**Thames Tideway Tunnel (WW010001)**

**London Borough of Southwark's Response to Item 10 of the Examination Timetable (Unique Reference Number: 10018659)**

London Borough of Southwark’s Response to Examining Authority’s First Written Questions issued 26 September 2013

Document Information
 Construction phase noise – summary of significant effects (day)
 Figure 1

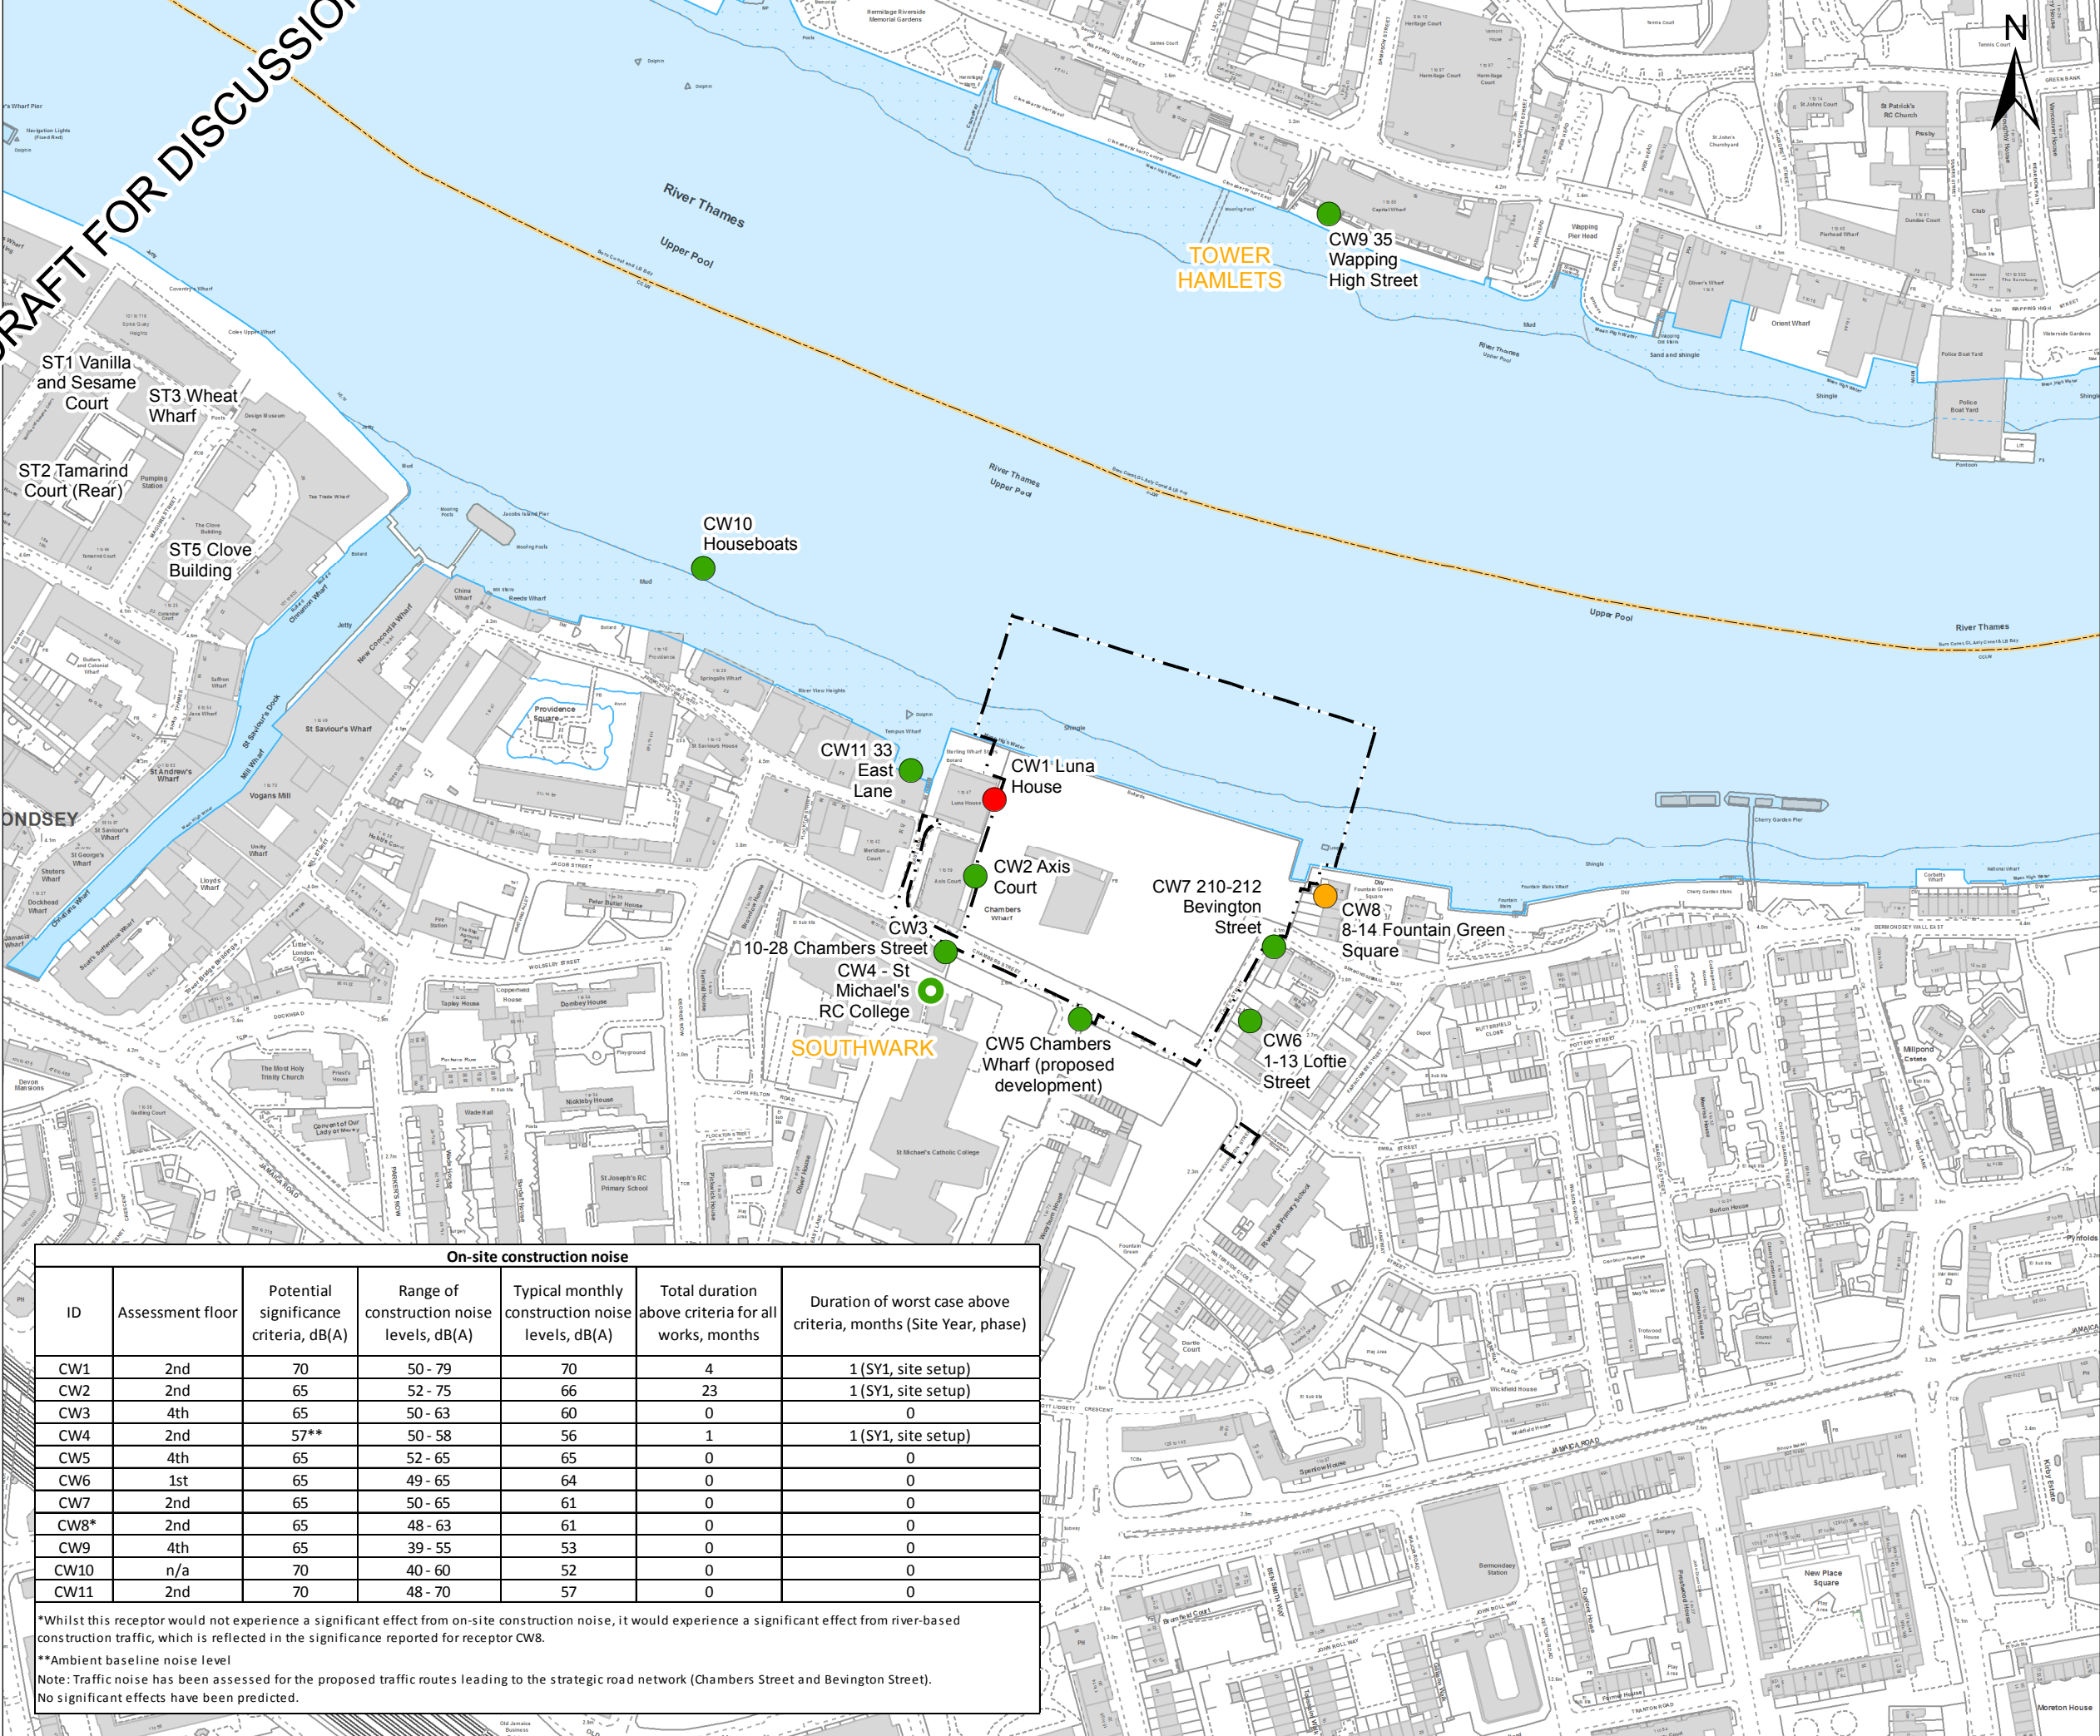
<b>11.2 (b)</b>	Ambient noise levels	LBS does not only look at the $L_{Aeq}$ levels, but will also consider the $L_{A MAX}$ and $L_{90}$ values for the same timeframe. This is because the $L_{Aeq}$ values will mask the variation in the ambient noise levels. At nighttime the baseline would be improved if the $L_{Aeq 5min}$ were provided.
<b>11.2 (c)</b>	Base level assessment	LBS does not consider that the information given in the ES can be used as a base level for the assessment of the impact of noise on residential and other receptors, as all the information has not been presented and the cumulative

effects of six years of construction has not been taken into account for the site.
<b>11.7-11.8</b>	Screening and noise impacts	<p>The data presented does not provide the assumptions used in the calculations and the program and the site layouts are only indicative. The values given are for a certain phase, not all the different phases.</p> <p>There are too many components of the programme that depends on the contractors discretion within the CoCP. Further, see comments in LBS' LIR on the CoCP Part B.</p>
<b>11.9</b>	Plan for each site showing location and type of noise mitigation	See LBS' LIR for comments on the applicant's noise and vibration assessment generally.
<b>11.18</b>	Assessment for schools	LBS has concerns about the impact of the TTT proposals on local schools. Comments on this are provided in LBS' LIR- please see Part 3 and the LIR Appendices.
<b>11.26</b>	Noise insulation and re-housing	<p>The Noise Insulation and Temporary Re-housing Policy (NITRP) submitted as part of the application appears to follow the model of similar NITRP for other projects in Southwark. However, the detailed wording needs to be amended and it needs to be attached to either a suitably wording requirement or provision of the s106 agreements.</p> <p>In terms of the NITRP wording, LBS requires:</p> <p>(a) that in paragraph 3.1.7a the words “or for a period of 3 or more nights (22:00 – 07:00) of working in any 7 consecutive nights” are inserted between “...fifteen consecutive days” and “or alternatively during 40 days.....” within the noise insulation criteria.</p> <p>b) in paragraph 3.1.8a the words “or for a period of 3 or more nights (22:00 – 07:00) of working in any 7 consecutive nights” to be inserted between “...fifteen consecutive days” and “or alternatively during 40 days.....” within the re-housing criteria.</p> <p>c) within the Glossary of the NITRP an entry for the term “lightweight building” used when referring to special cases.</p> <p>d) in respect of "Construction Groundborne Noise Criteria for Temporary Rehousing that A building will be eligible where the structure - borne noise due to the construction works measured or predicted at a representative point within the building exceeds the following criteria</p> <p>40 dB <math>L_{A MAX S}</math> between 19:00 - 07:00</p>
